Job Reference Number: **2021-50**

**RE: Sunnycliff, Trebarwith**

**Supporting statement following previous planning approval**

West 1:100 @ A1 0m 2m 4m

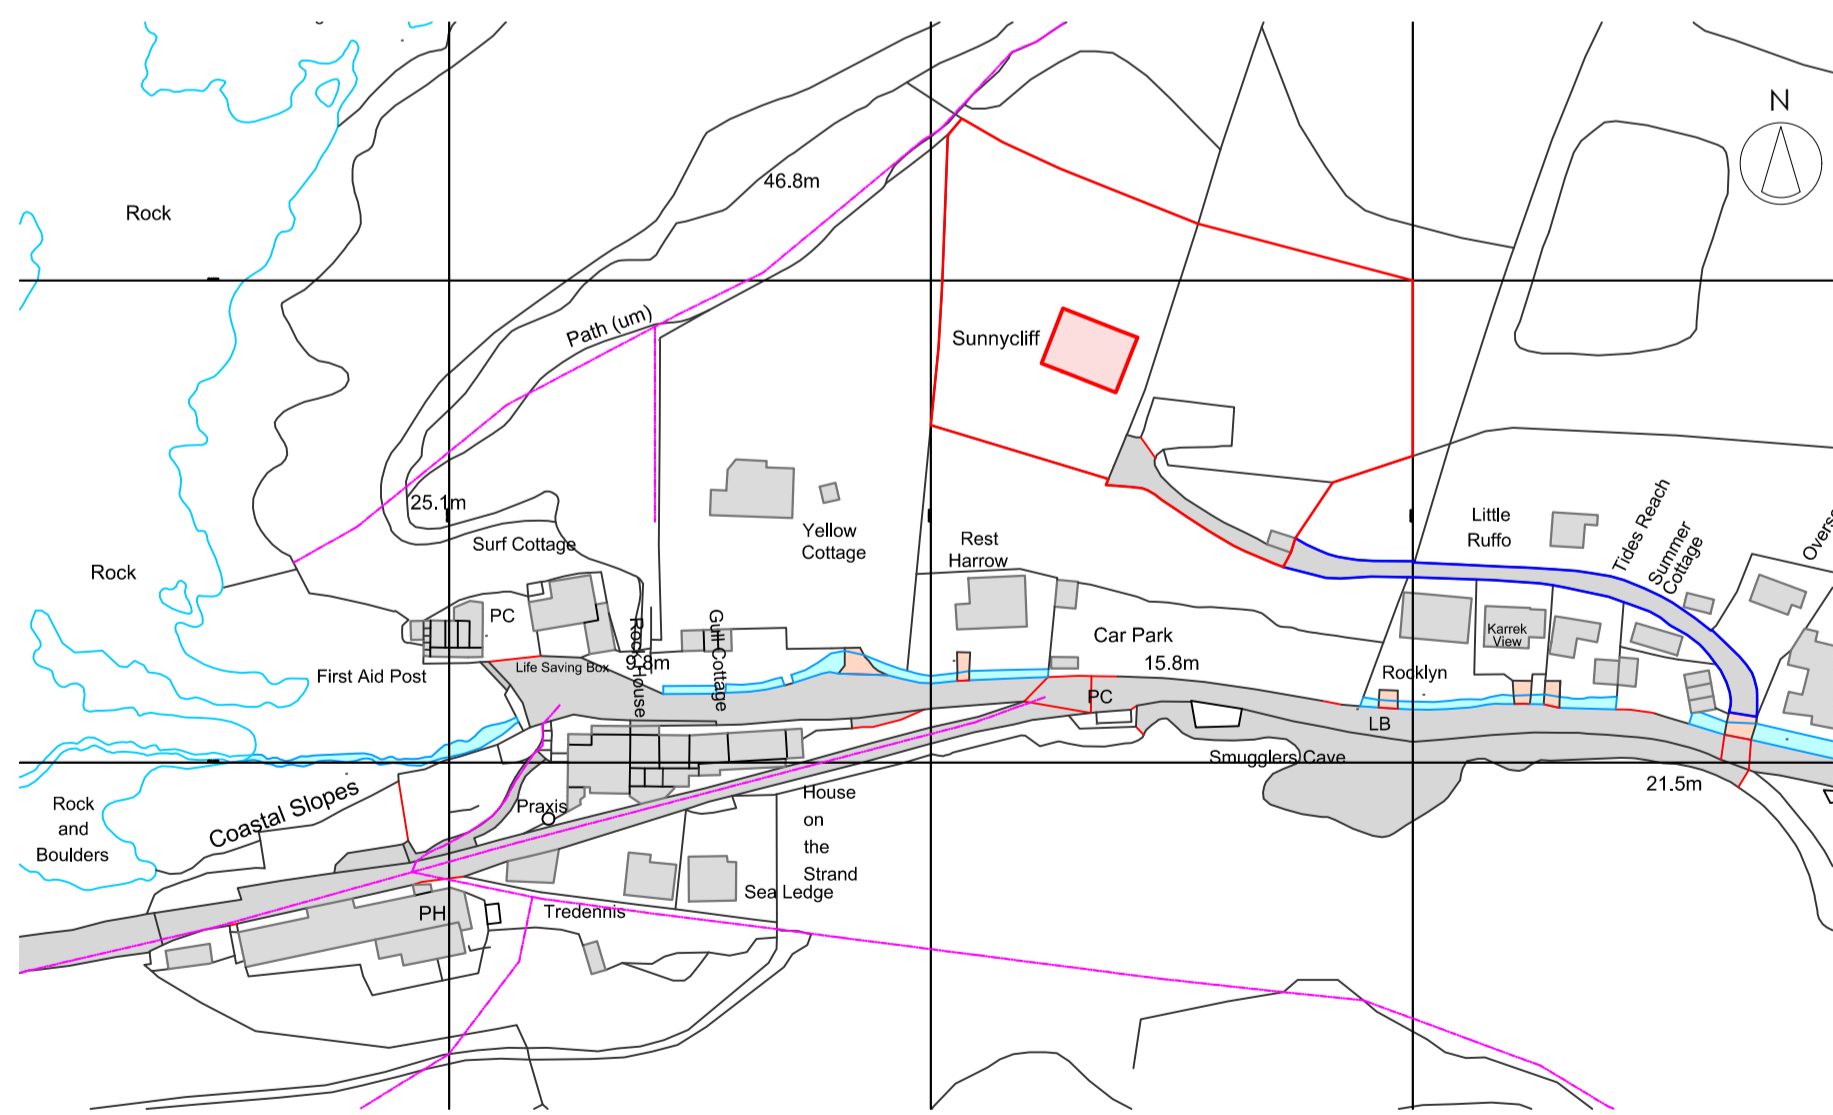
This amendment is being requested as a requirement for construction purposes only, the current approved roofline makes the construction of this roof section unnecessarily complicated, regrettably this wasn't taken into consideration prior to previous submission. The amend has been requested by the builders and I concur that this should be amended. Please note the glazing element will not change in size, this amend is, as stated, merely to aid construction.

Overall, the variations to the previously approved design are negligible, but benefit to the building as a whole. The integration of solar will aid in the day to day running of the property and its longevity, working towards the UK's carbon zero initiative by 2030. The raise in ridge line to the projection on the west elevation will match that of the existing blending the new addition with the existing roof.

Proposed Block Plan 1:500 @ A1 0m 10m 20m

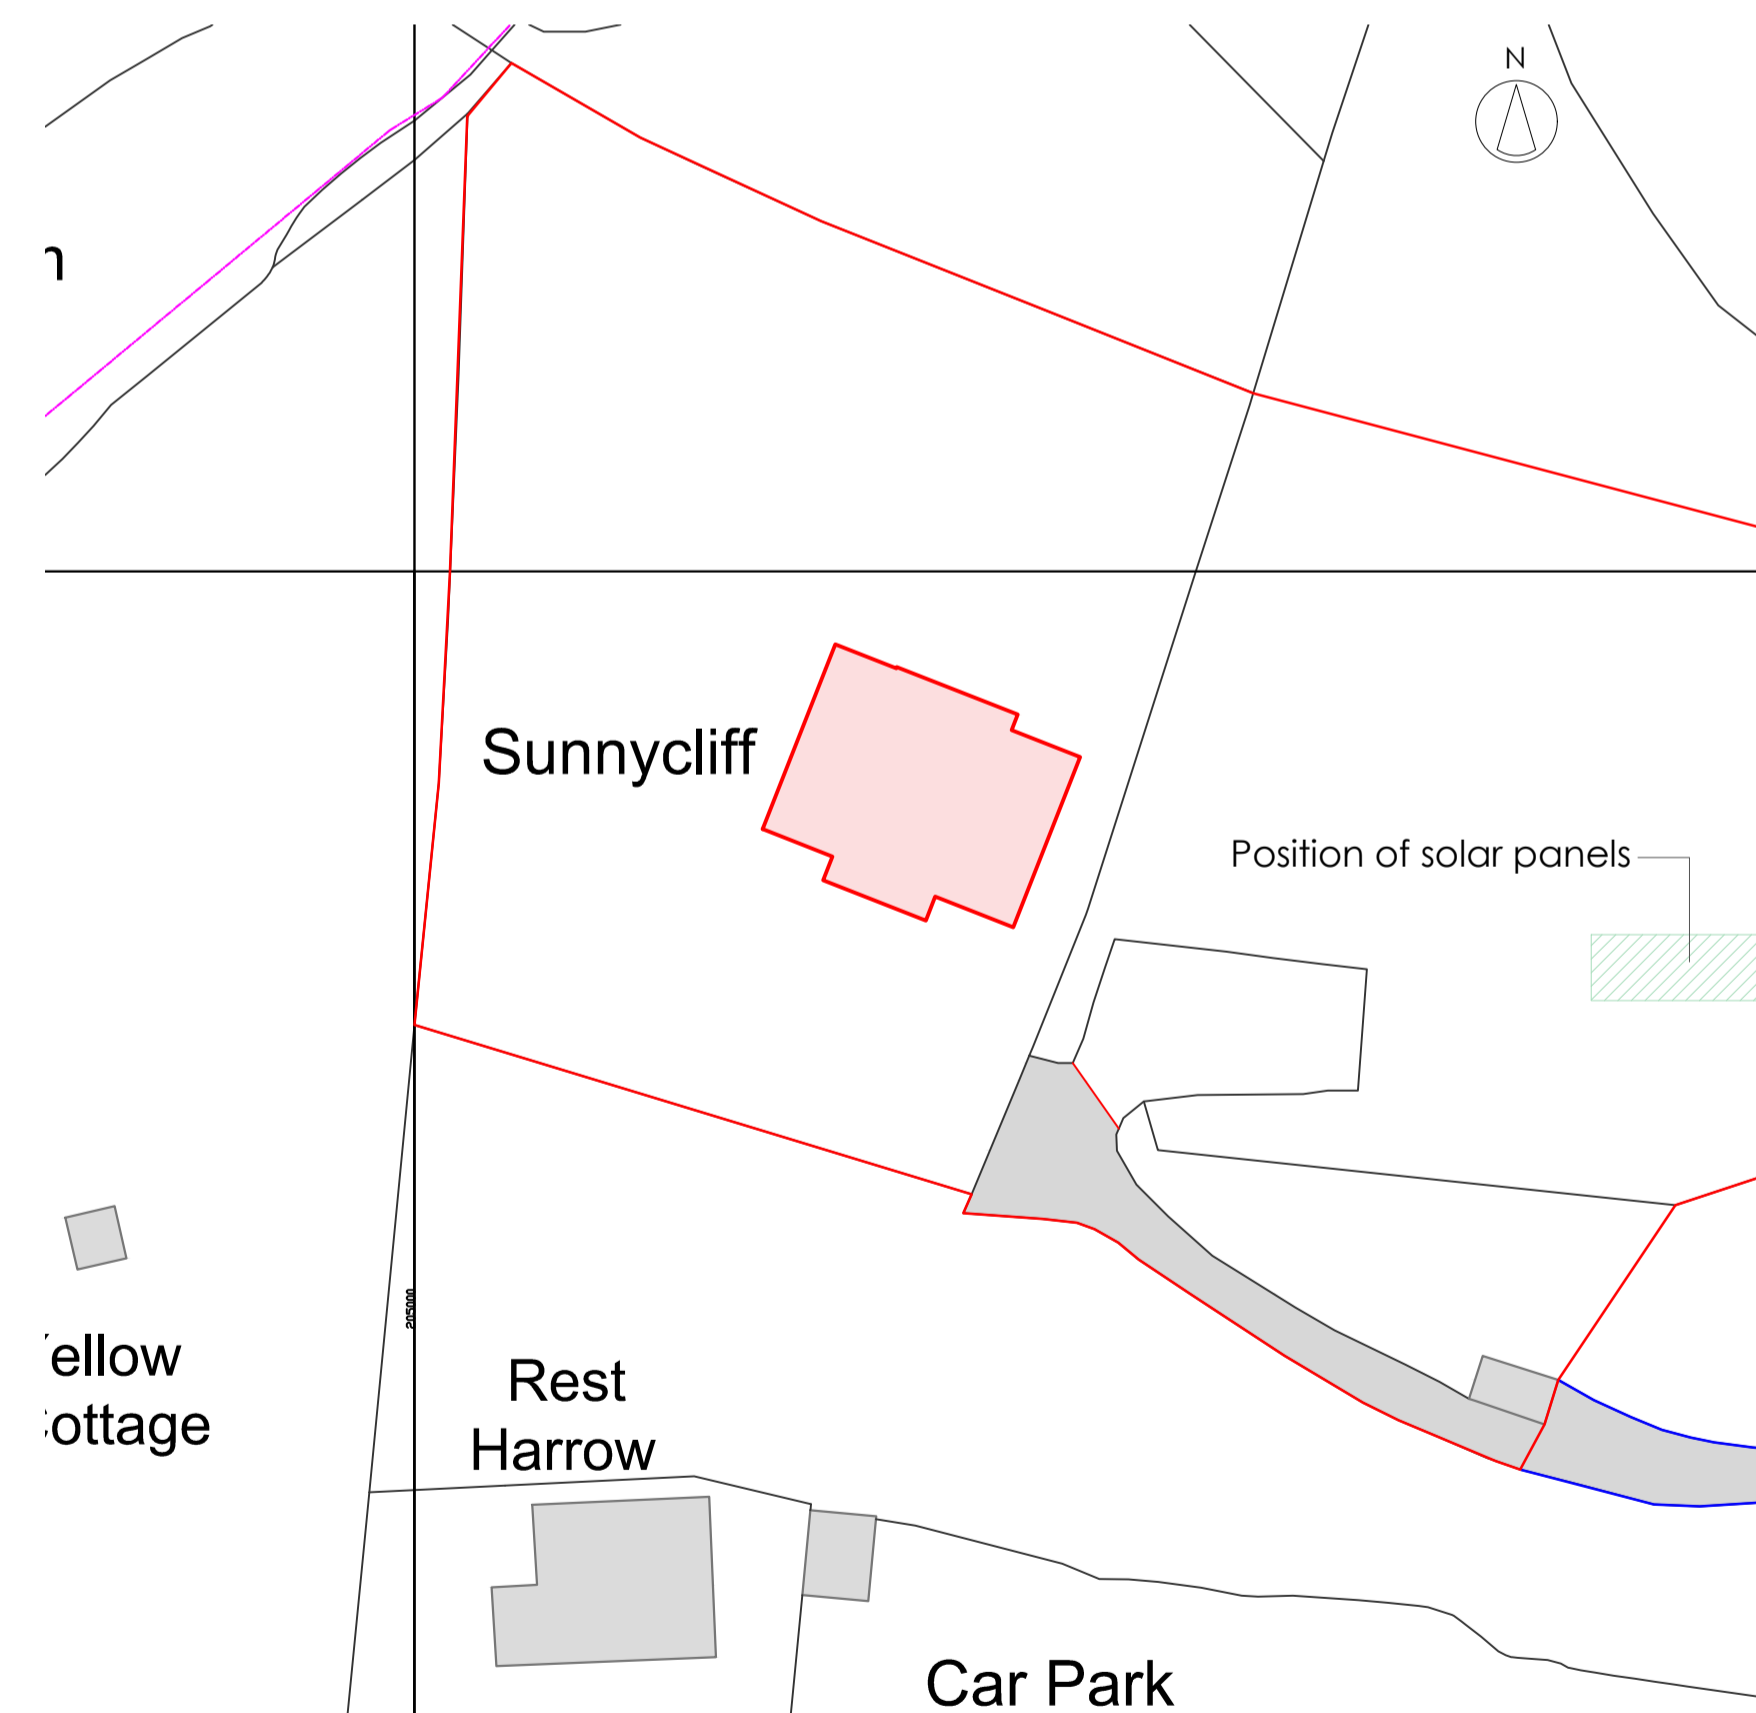
We wish to use renewables where possible and believe it would be remiss to not install solar at our property. Having reviewed numerous positions across our garden, we believe we have located a position that optimises the use of the panels, while mitigating any potential visual impact to the other properties on the other side of the valley. The ideal positioning (from the experts!) would have been directly below the cottage, however we felt this might impact visually whereas the proposed positioning should minimise impact to the surroundings. The electrician has attempted to mark on the attached image where we suggest they be placed. He is advising that it would be 2 banks of 8 panels each (16 panels in total).
